Subject: Environmental Impact Statement – Mixed-use development with in-fill affordable housing at 215 and 229-239 Pitt Street, Merrylands (SSD-79844224)

CPHR comments on the Environmental Impact Statement – Mixed-use development with in-fill affordable housing at 215 and 229-239 Pitt Street, Merrylands (SSD-79844224)

- *Environmental Impact Statement* (Mecone, 26 March 2026)
- Appendix K – Civil Engineering Plans (EI Consulting Engineers, 8 October 2025)
- Appendix T – Flood Impact Risk Assessment (EI Consulting Engineers, October 2025).

Figure 7: 1% AEP flood level map (Source: Cumberland Council Flood Advice Letter, 03 Sep 2024)

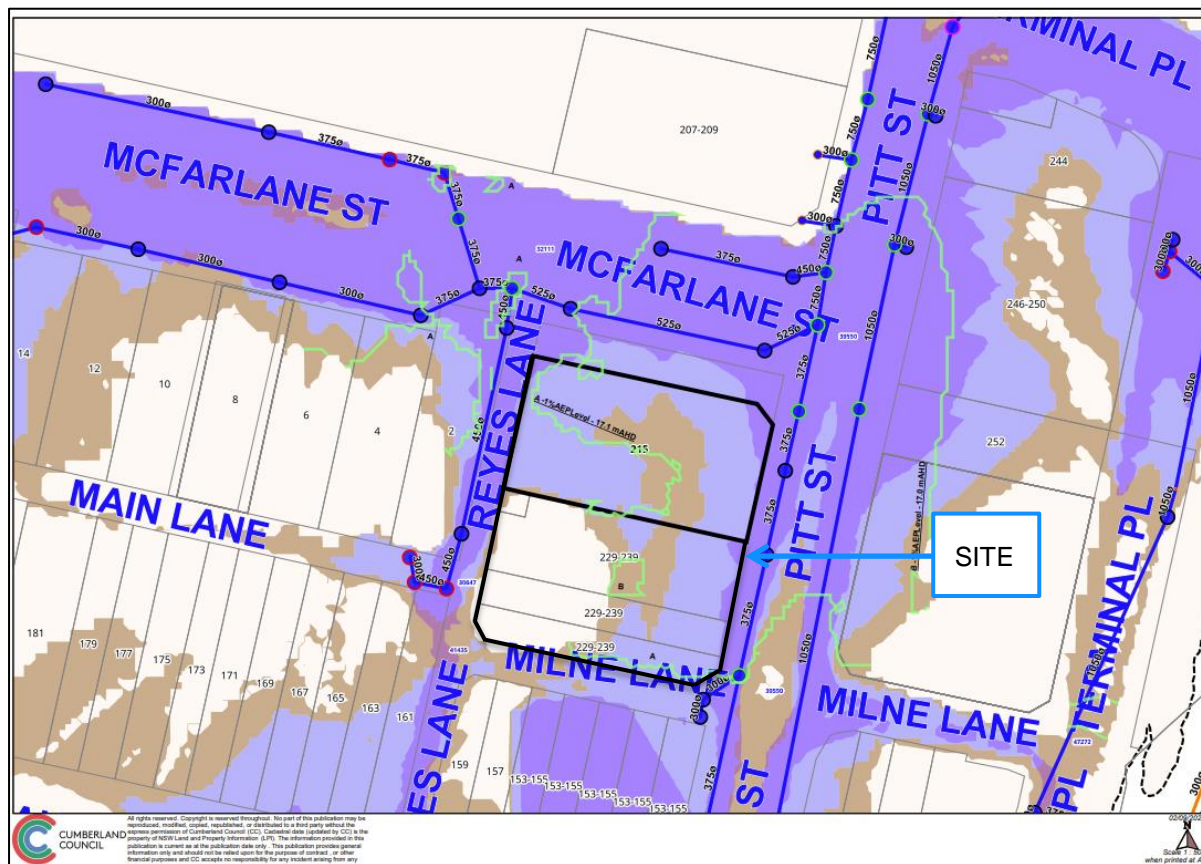
1.	FIRA has not addressed the SEARs	The Flood Impact Risk Assessment (FIRA) has not addressed the Secretary environmental assessment requirements (SEARs) for the SSD. The following information has not been provided: • Flood levels are only provided for the existing 1% Annual Exceedance Probability (AEP) event and the Probable Maximum Flood (PMF) scenarios. Post-development flood levels are not included. • The FIRA has not provided mapping of flood behaviour including depth, velocity, hazard and flood function. • The FIRA has not considered other events or sensitivity analysis, including the impacts of climate change. • The proposal has not considered the PMF in its design or emergency response. The FIRA provides an evacuation route which enters high hazard flooding and states that evacuation is highly risky in a flood event. The FIRA also recommends shelter in place but has not demonstrated consistency with the design requirements identified in the Shelter in Place Guideline for flash flooding (DPHI, 2025). Furthermore, the floor levels and basement car park levels have been designed to the 1% AEP + Freeboard, which is 2m lower than the PMF level. Recommendation: Prepare a FIRA that is consistent with Flood risk management guideline LU01 - Flood impact and Risk Assessment. The FIRA is to: • Identify flood behaviour (depth, velocity, hazard and flood function) in the existing and proposed scenarios. • Identify the impact of the development on flood behaviour and the impacts of climate change on the development. • If shelter in place is determined to be the most suitable emergency response, demonstrate consistency with the Shelter in Place Guideline for flash flooding (DPHI, 2025). • Any mitigation measures are clearly described and modelled (where necessary). This is not an exhaustive list, and the applicant should refer to the abovementioned guideline.
